Consultation Response from: KC Environmental Health (Pollution & Noise Control)
2025/90708 - Land at Merchant Fields Farm, off Hunsworth Lane, Cleckheaton

Discharge of details reserved by conditions 3 (Construction (Environmental) Management Plan), 6 (Temporary surface water management details), 8 (Proposed internal adoptable roads), 9 (Permanent site entrance details), 16 (Surface water attenuation details), 17 (Details of Swale/ditch management), 19 (Phase II Site Investigation details), 20 (Remediation Strategy), 25 (Noise Impact Assessment), 30 (Arboricultural Method Statement/ Tree Protection Plan), 34 (Biodiversity Gain Plan) of permission 2024/91260 for Variation of conditions 2 (plans and specifications) and 35 (removal of permitted development rights) on previous permission 2021/92801 for erection of 291 dwellings with associated works and access from Hunsworth Lane and Kilroyd Drive – revisions to house types, unit size mix and layout

Responding Date:
 5th September 2025

Condition 20 - Remediation Strategy

status:	FOR CONSTRUCTION	drawn:	JL	date:	FEB 23
project:	(2022 Regs)	checked:	-	scale:	@ A4:1:10
title:	JABLITE (BRICK) RADON	job no:	SD	drg no:	SD22-FN-12 B

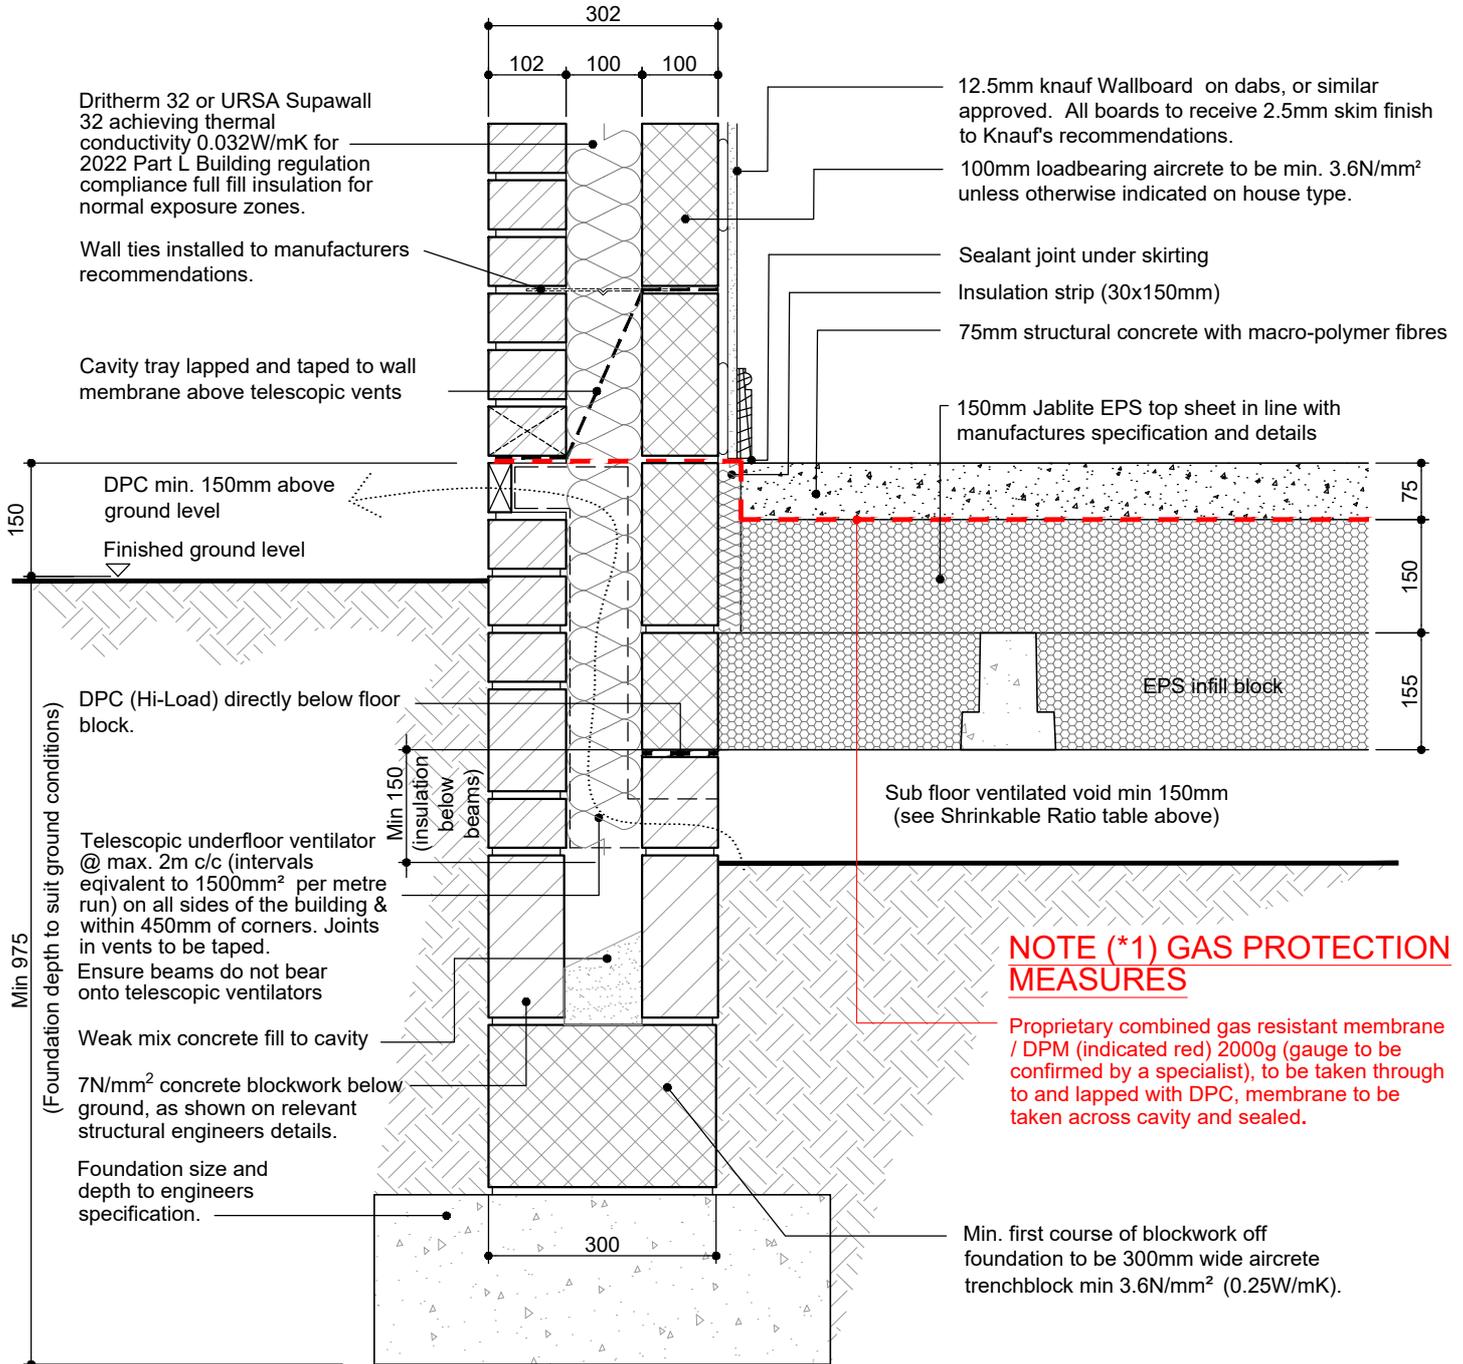
We have commented on the remediation strategy on 3 previous occasions: -_14th May 2025, 3rd of July 2025 and the 14th of August 2025. In our last response we required information in relation the gas protection measures.

Since then, a plan, drawing no: - SD22-FN-12 and a letter from Lithos Consulting dated 31/10/2019 has been submitted. The applicant has also confirmed *“All foundations on site will have a 2000 gauge DPM due to the radon being within 3-5% as well as Beam and Block floors with ventilated subfloor voids, as shown on our foundation schedule and detail attached. This combination meets the point score requirement indicated within the gas risk assessment”*

The gas protection measures have been outlined.

On the basis of the professional judgement of the Lithos Consulting and the evidence and interpretations presented, we recommend discharge of the condition 20.
